From: Amanda Scholes on behalf of Planning.Responses
Sent: 02 July 2020 07:33
To: Planning Scanning
Subject: FW: Planning Consultation on M/28/20/DOC

Engineers comments;

The level of detail supplied is currently insufficient to enable the discharge of conditions 11, 13 or 14.

Figure 1
Groundwater Level at all Boreholes

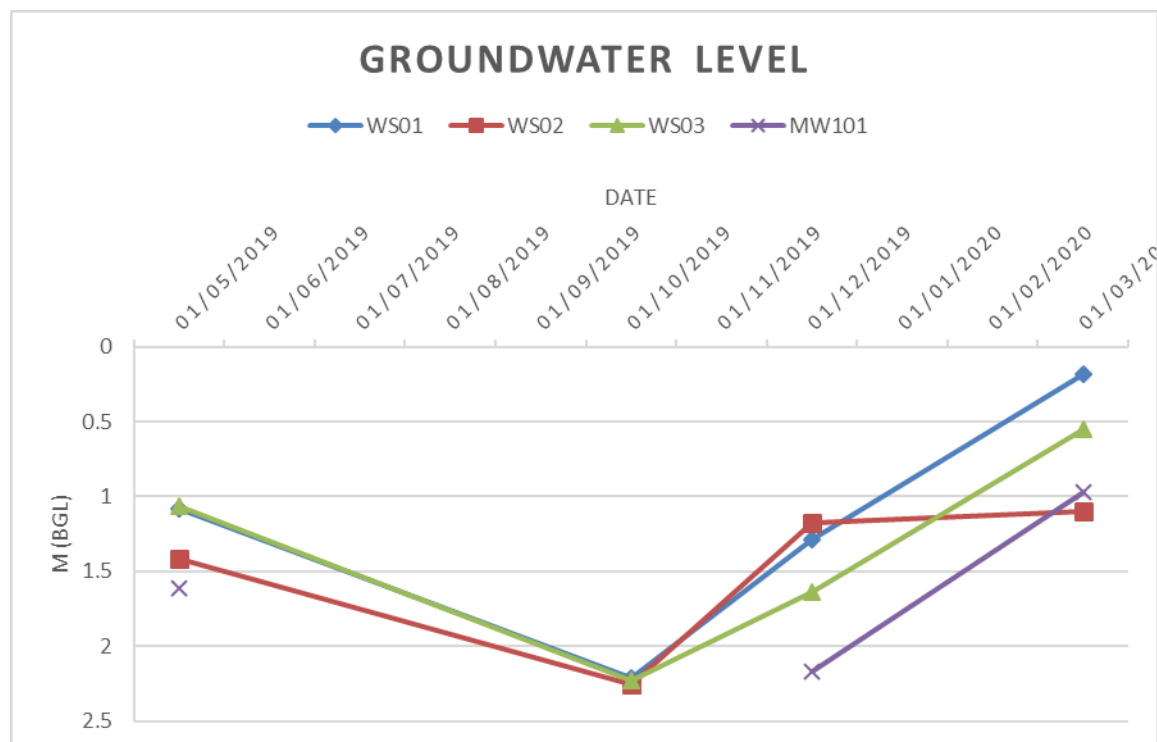
Firstly, we need to be sure that shallow infiltration is not possible, as part of an overall scheme. Please provide a plan showing all the groundwater monitoring point locations and the monitoring results for all, not just WS02. Achieving 1m freeboard between the base of structures and the peak recorded groundwater level is not a requirement in this particular area, so long as the base is above the peak recorded level. This information will dictate as to whether shallow winter infiltration testing will be required.

Figure 4
Route 1 Plan and Section AA'

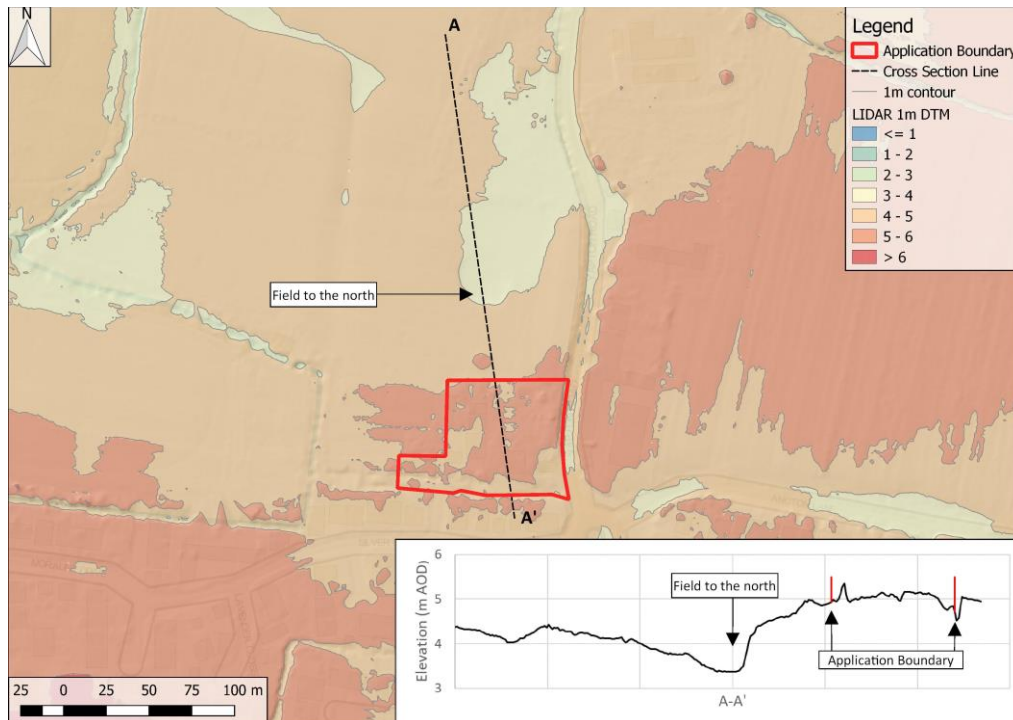
The applicant should also provide topographical evidence to show that no overland/exceedance run off flows from the field to the north will have any detrimental effect on the development/suds.

Site: YAPTON POULTRY FARM
Project: MIDDLETON RESIDENTIAL
Date: 01/07/2020
Drawing: SITE VISIT DISCUSSION
APPENDIX 02

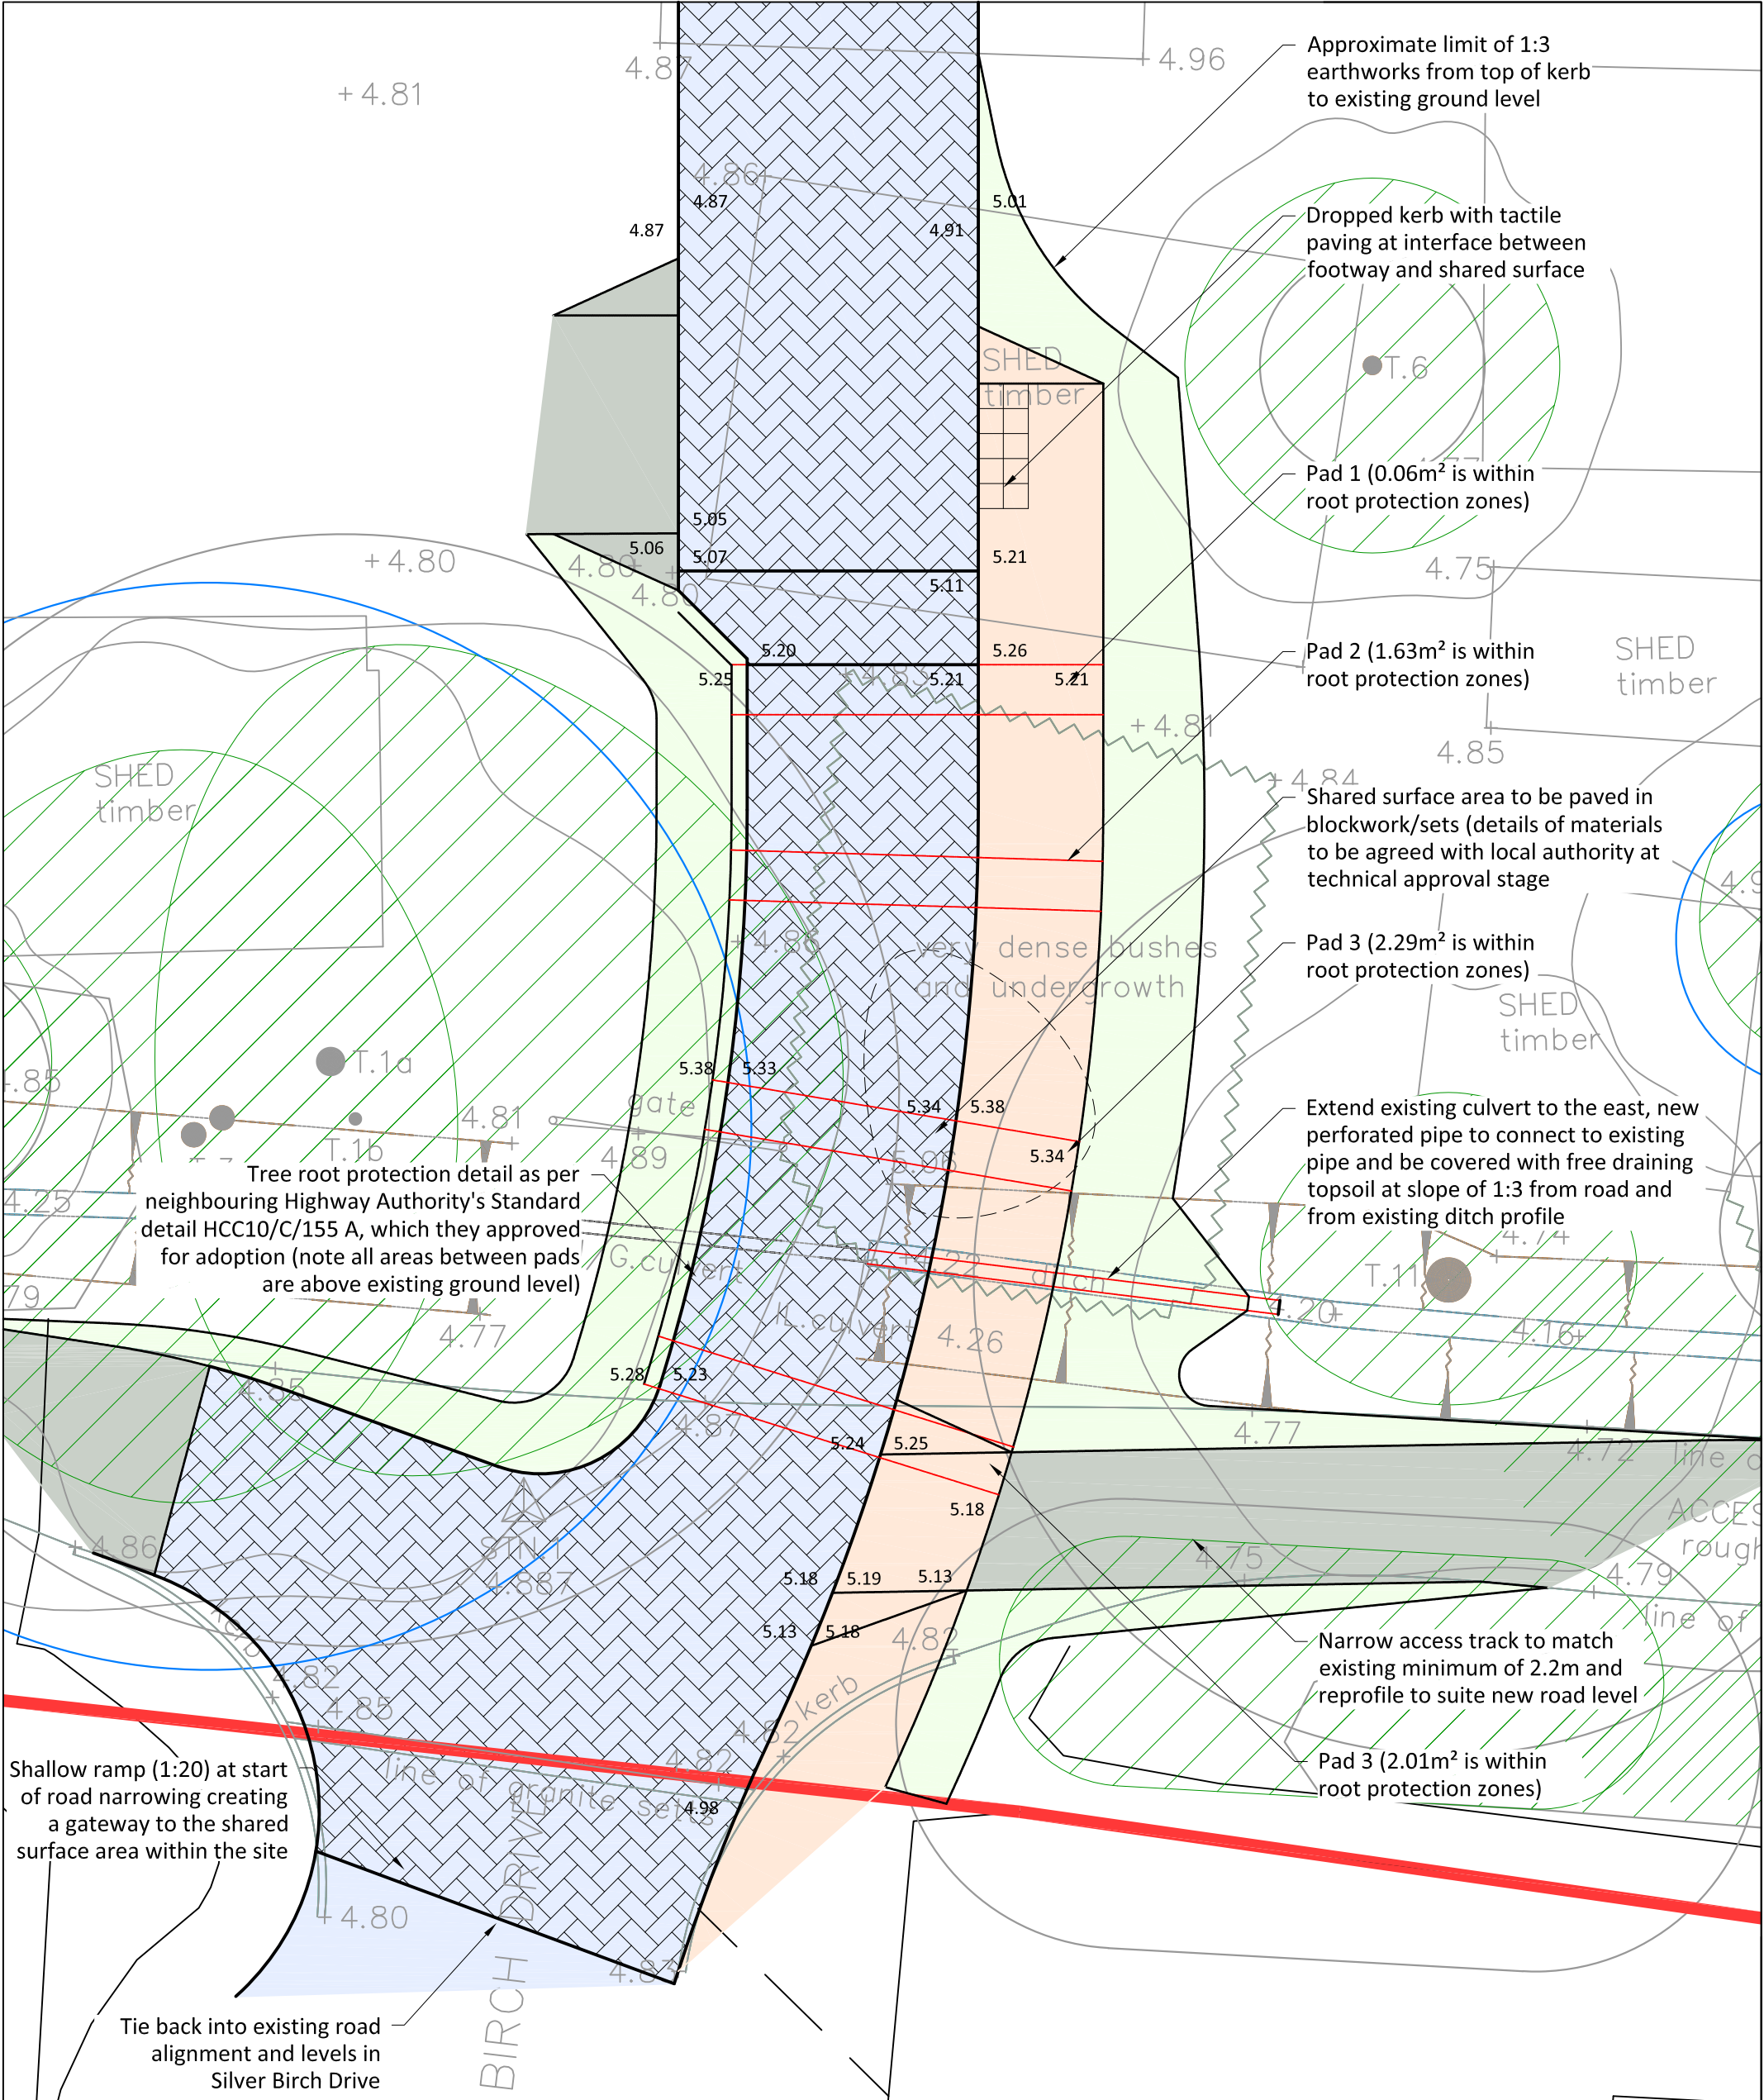
Regarding the ditches on the southern boundary, it is very likely that these will need improvements and I suggest a meeting takes place on site to look at these. Land Drainage Consent will be required for any alterations to them, including culverting and any discharge structures. This will all need to be fully detailed on the drawings.
